June 7, 2019

**Re: Horizon 3**  
**8830 horizon Blvd NE Albuquerque NM**  
**Traffic Circulation Layout**  
Engineer's/Architect's Stamp **05-28-2019** (C17D127)

Based upon the information provided in your submittal received 06-05-19, the above referenced plan cannot be approved for Building Permit until the following comments are addressed:

Traffic Circulation Layout  
TCL001

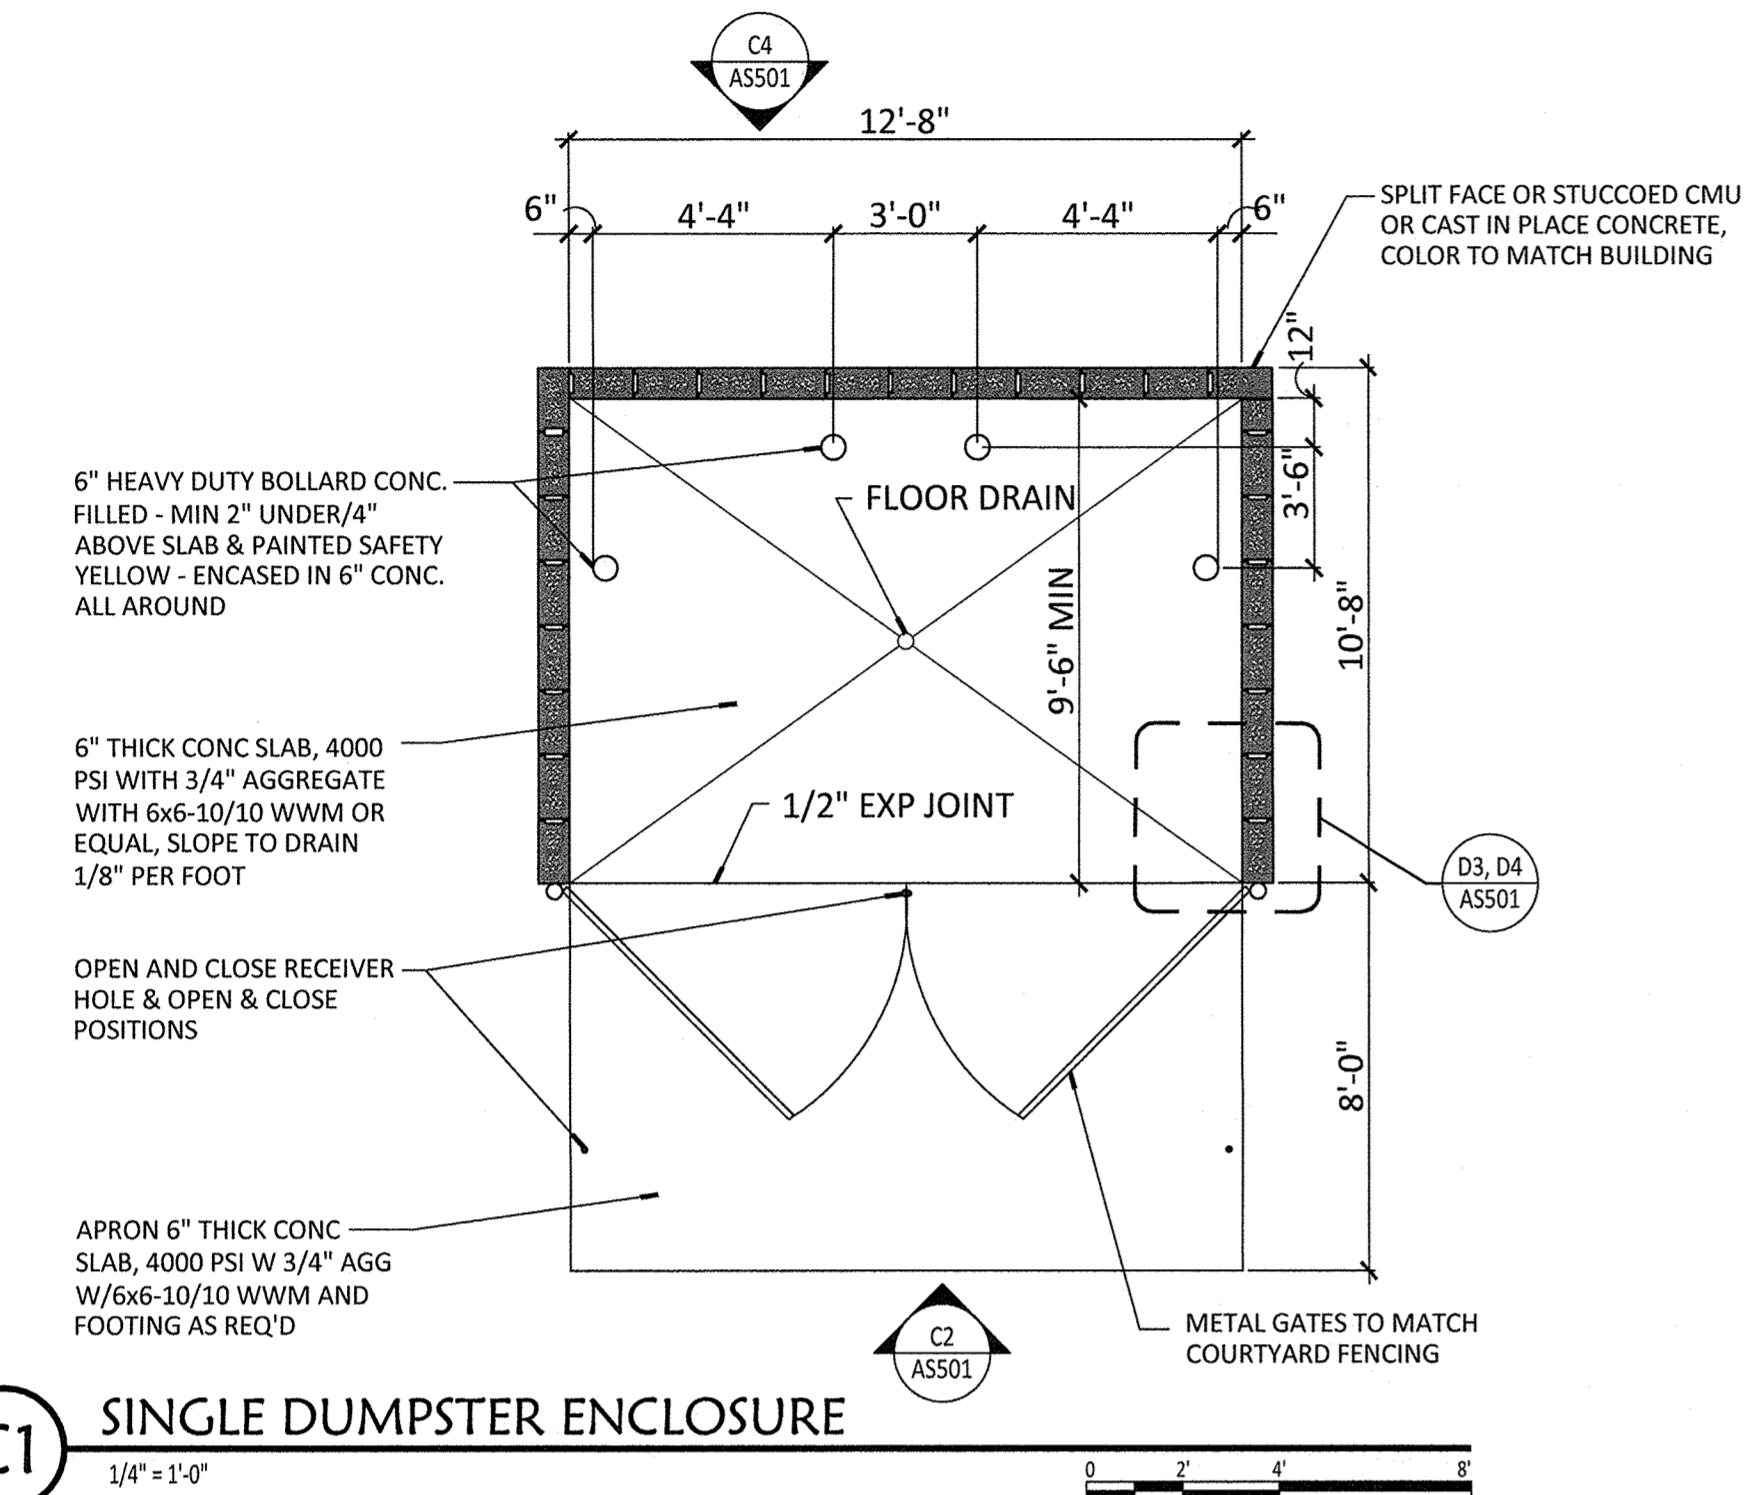
5. Please refer to the attached file for bike rack design as IDO and DPM have new requirements.

5. Bicycle parking should be in the form of a corral or other vertical feature that clearly demarcates the space as intended for bicyclists only. Corrals are most appropriate at street corners. See Figure 3.8-3 for examples.
